Application Ref:	3/2019/0569	 Ribble Valley Borough Council <small>www.ribblevalley.gov.uk</small>
Date Inspected:	25 th July 2019	
Officer:	LG	
DELEGATED ITEM FILE REPORT:		APPROVAL

Development Description:	Erection of single storey events/function building. Extension of service road and grass over hardstanding area currently used as a base for marquee.
Site Address/Location:	Foxfields Farm, Whalley Road, Hurst Green

PROPOSED SITE PLAN 1 : 500

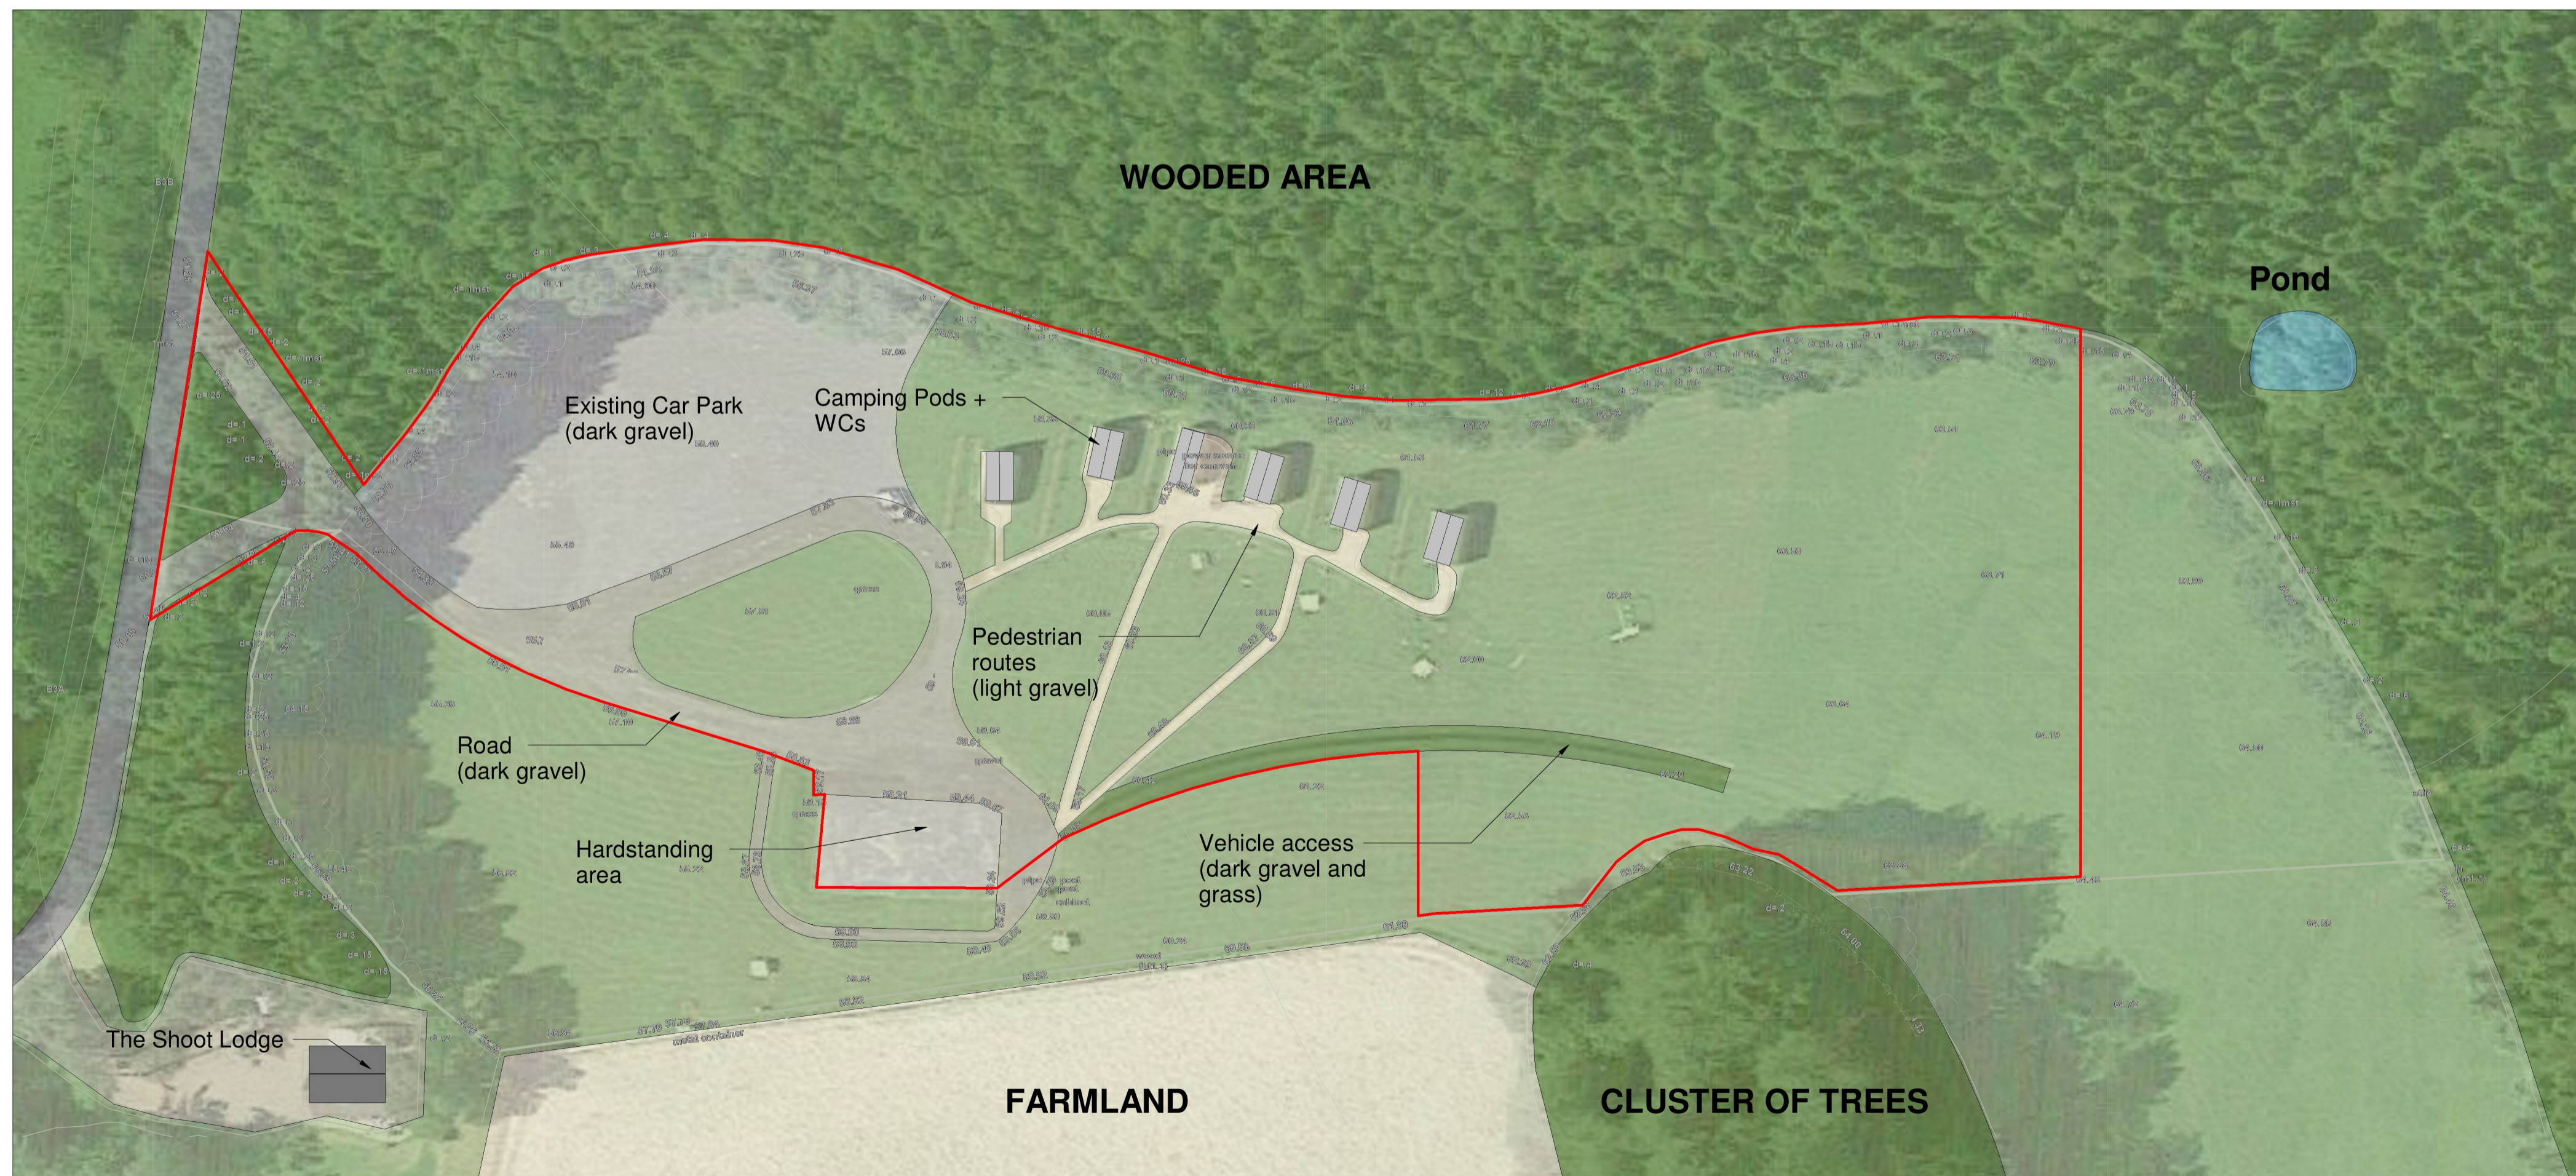
An indicative drainage strategy is provided which states that foul waters would be discharged to a new septic tank/package treatment plant, with surface waters via an existing watercourse or soakaway if possible.

A condition will be added to ensure that a detailed scheme is submitted and approved prior to installation and first use.

SWEPT PATH ANALYSIS FOR 12m LONG COACH - IN MANOEUVRE

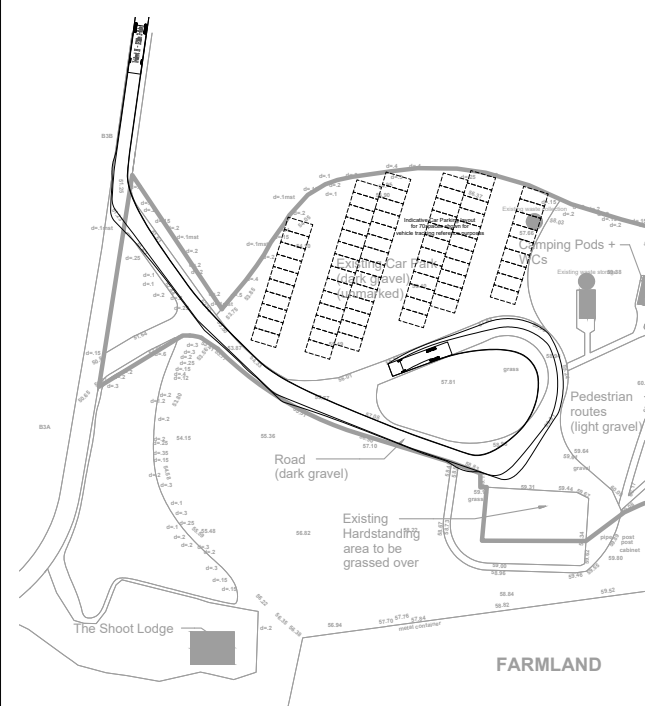
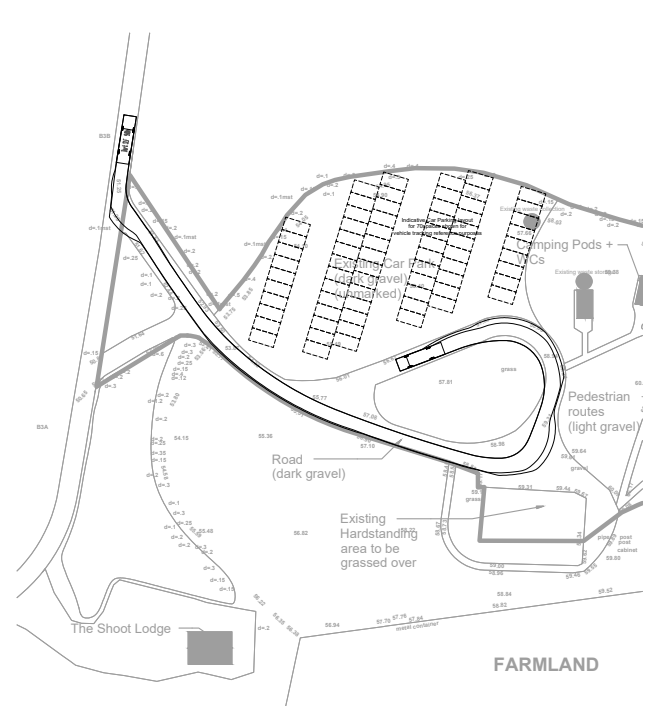
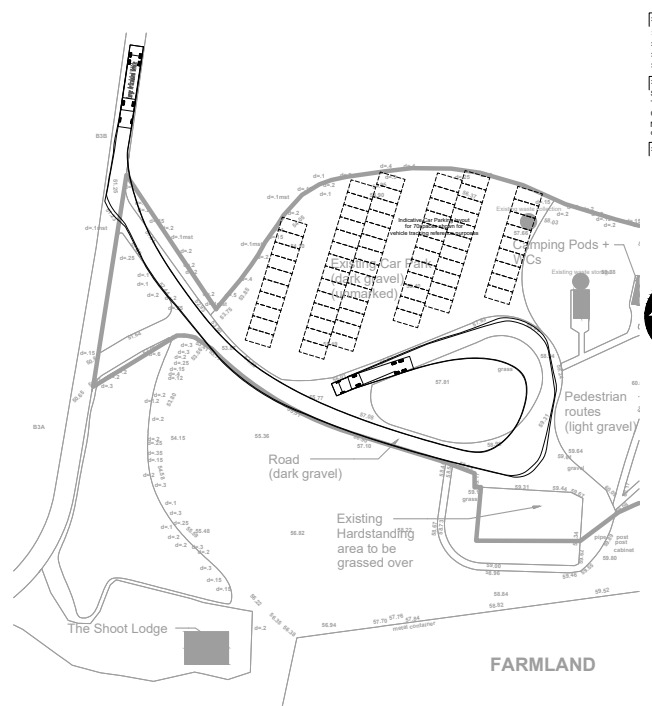
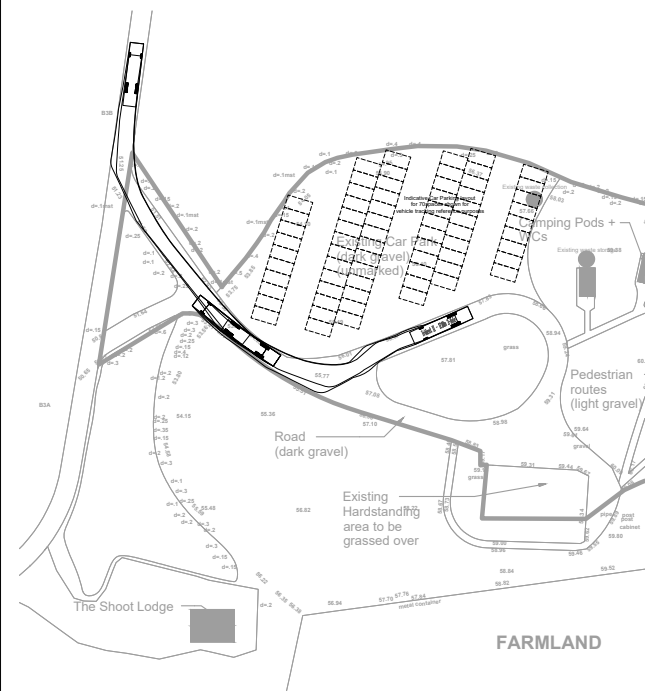
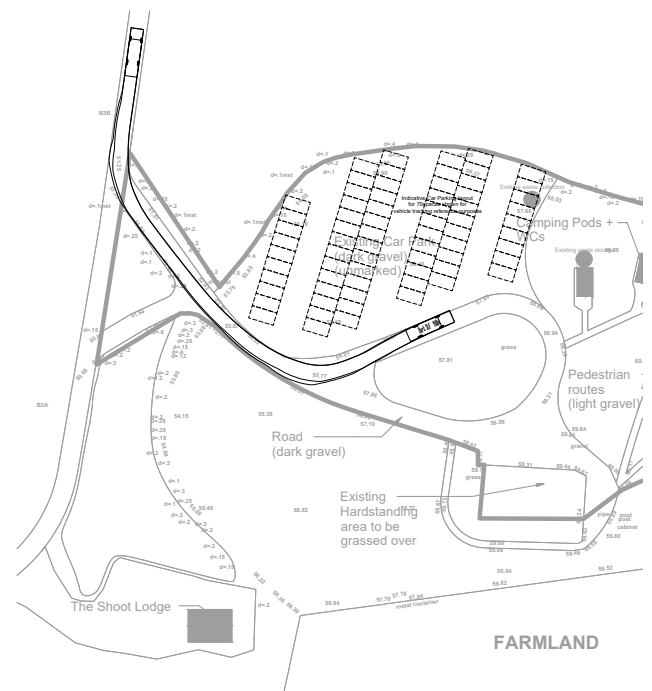
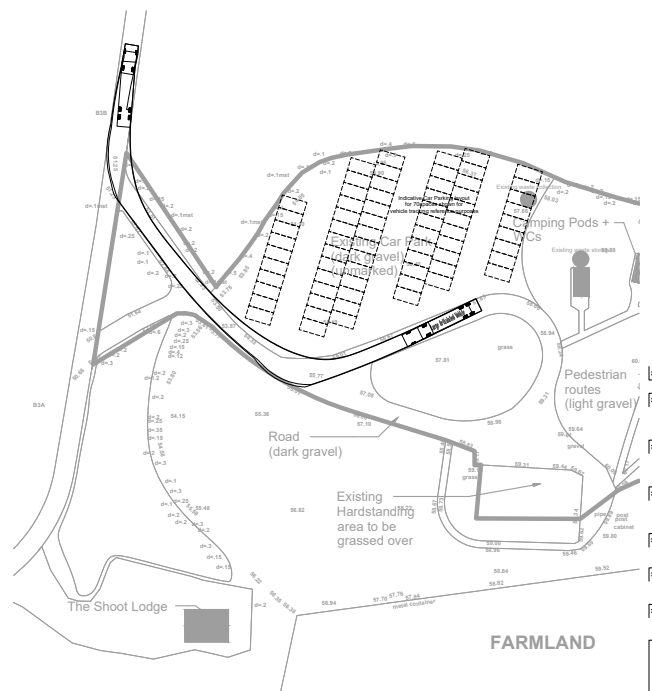
CONSULTATIONS:	Highways/Water Authority/Other Bodies
LCC Highways:	Originally raised several queries in relation to parking provision and the ability of larger vehicles (coaches etc.) to access the site without causing undue harm and adverse highway safety issues. Following receipt of further information from the applicant, these matters have been addressed to the satisfaction of LCC Engineers and no objections are raised.
United Utilities:	No issues subject to the implementation of a drainage scheme which accords with the order of priority detailed within the NPPF and NPPG.
LLFA:	No comments to make based on the nature and scale of the scheme.

Following the submission of further information regarding parking capacity and swept paths leading to the site, LCC Engineers are satisfied that the proposals would not result in significant or unacceptable highway issues.

The swept paths confirm that larger vehicles, such as coaches can access and turn within the site without difficulty. This would also aid more sustainable transport methods with groups arriving in a single trip, rather than by several individual vehicles.
